# CITY OF ALBUQUERQUE

August 20, 2018

**Re: Shops @ the 24s  
32424 Louisiana Blvd NE  
Grading and Drainage Plan  
Engineer's Stamp dated: 8/14/2018 (H19D001)**

**EXHIBIT A
DETENTION POND & STORM DRAIN
2424 LOUISIANA BLVD
LOT 3-A-1, BLOCK C**

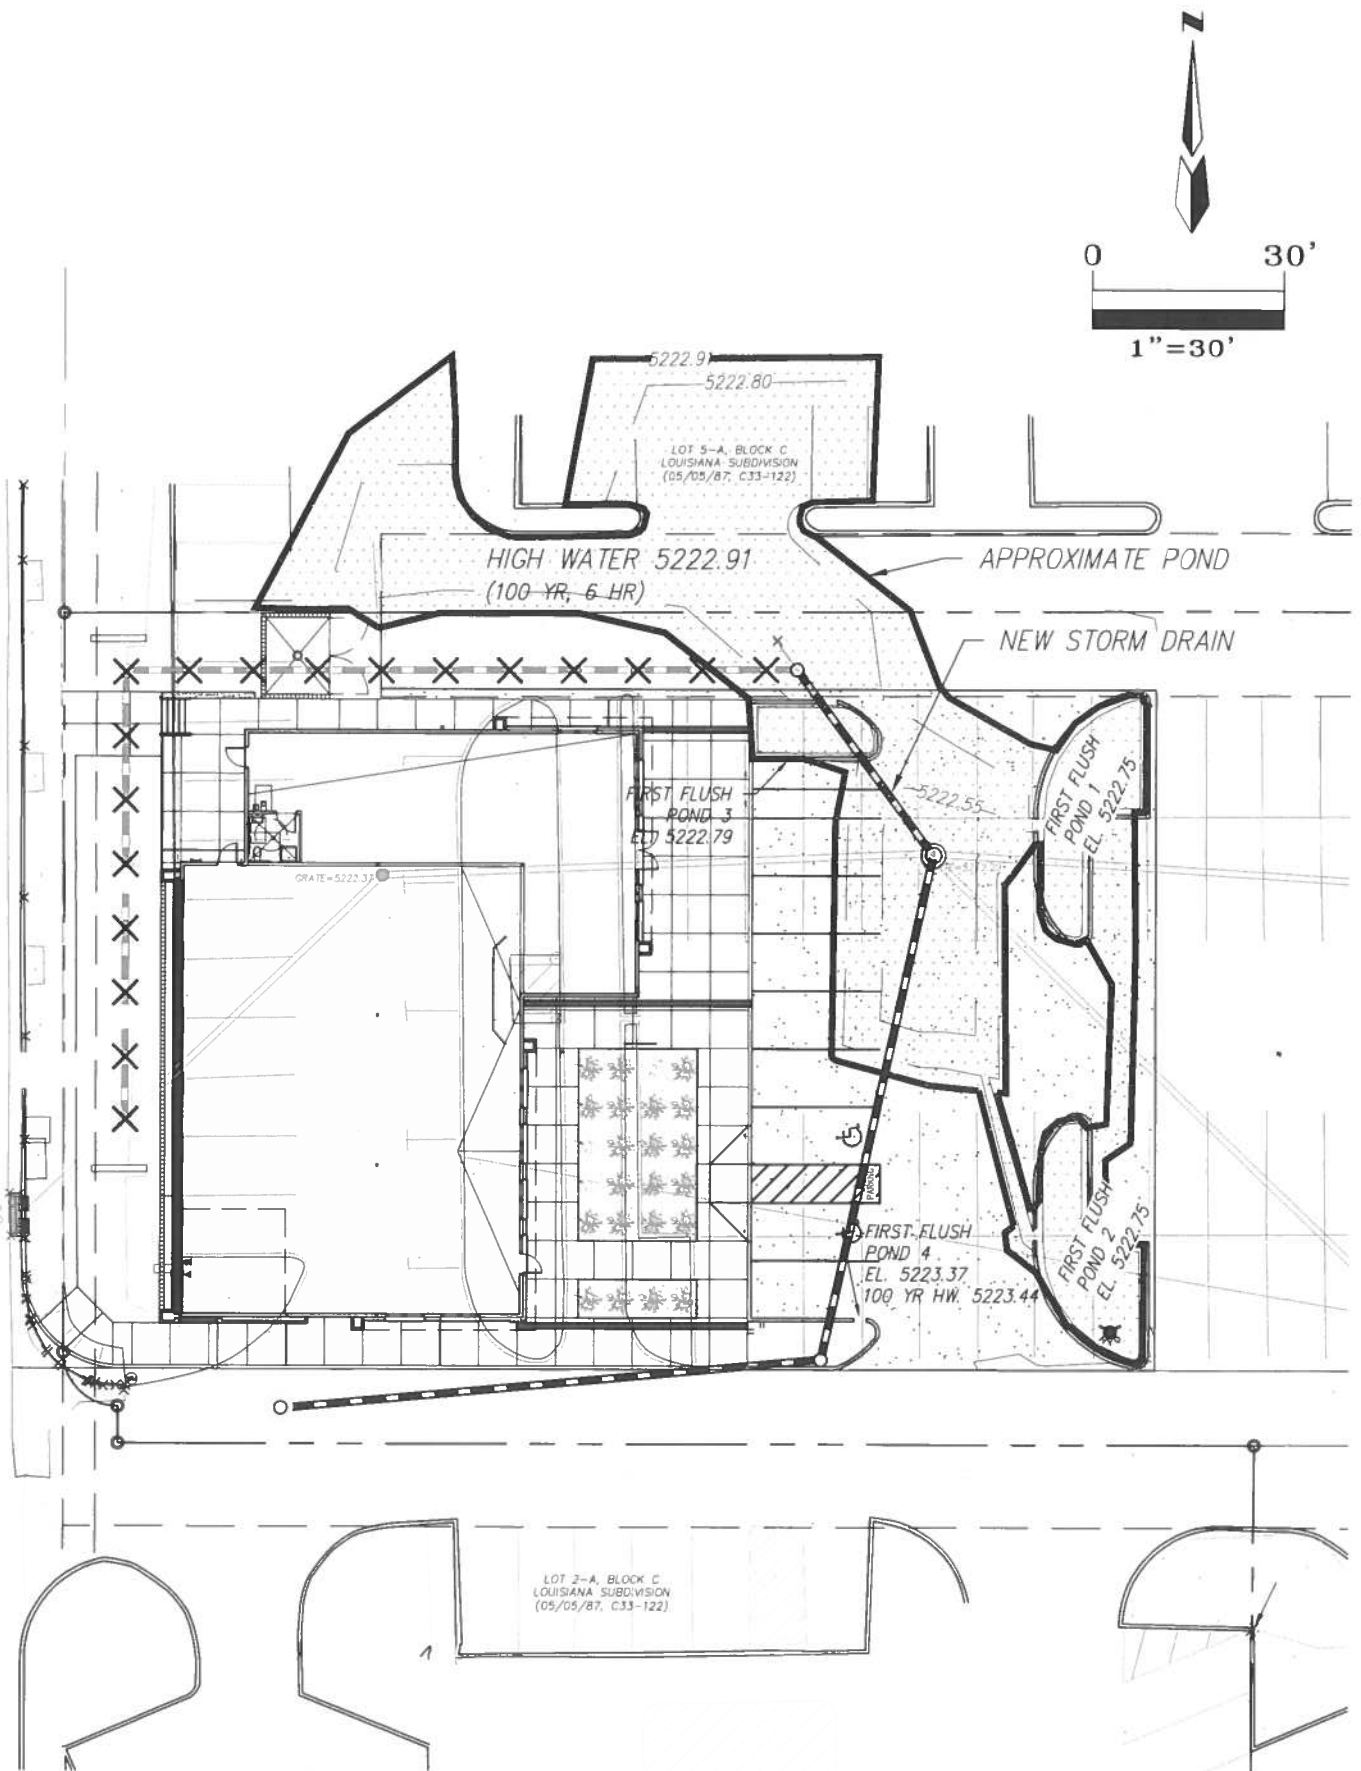
3. A Drainage Covenant is required for the detention/retention ponds and private storm drains on this lot. The original notarized covenant, pond exhibits (legible on 8.5x11 paper), and recording fee (\$25, payable to City of Albuquerque) must be turned into DRC (4th, Plaza del Sol) for routing. Please contact Charlotte LaBadie
